Application for Removal or Variation of a Condition following Grant of Planning Permission or Listed Building Consent

Erection of 3 no. dwellings with formation of new vehicle accesses

22/02376/FUL

Minor amendment to Plot 3, extension of the kitchen/ dining area to match the layout of Plots 1 & 2.

Drawing Number	Rev.
<i>026-MRDV-A-P00010</i>

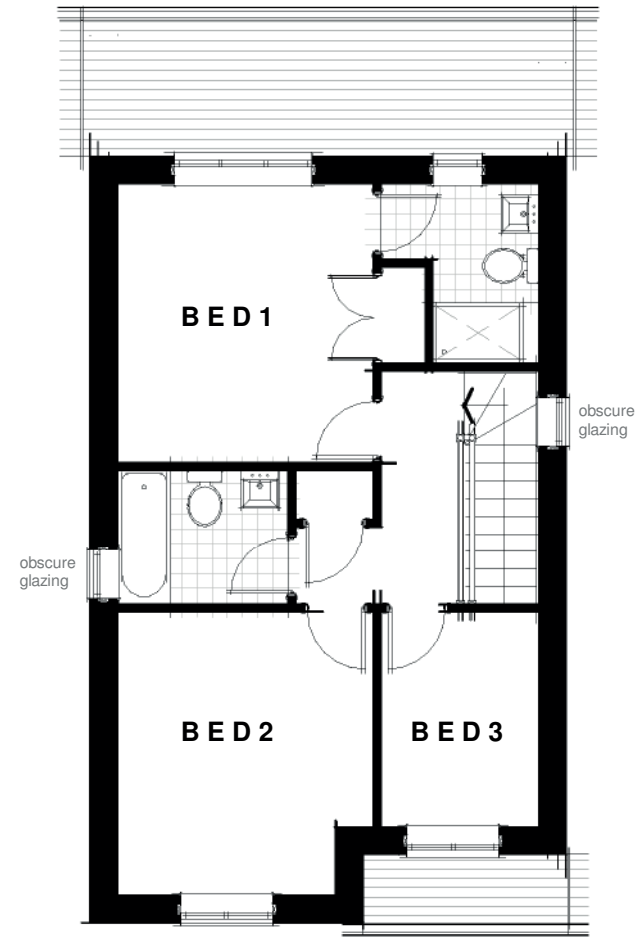
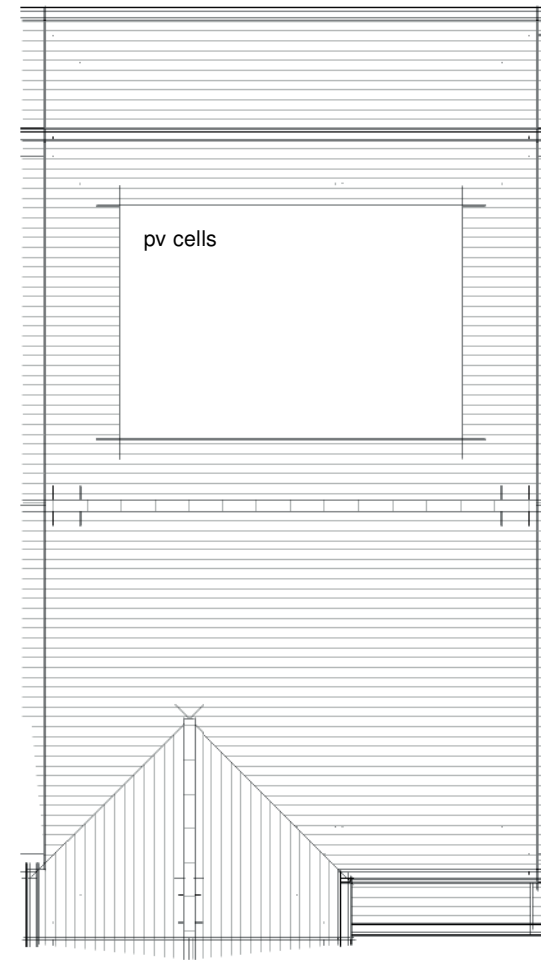
We wish to substitute the approved drawings for Plot 3; Proposed site plan_P03, Proposed plans - plots 3_P30, Proposed elevations - plot 3_P31, for the new drawings as follows; 026-MRDV-A-P00000_Proposed Site Plan, 026-MRDV-A-P00010_Plot 3 - Proposed Plans, 026-MRDV-A-P00020_Plot 3 - Proposed Elevations
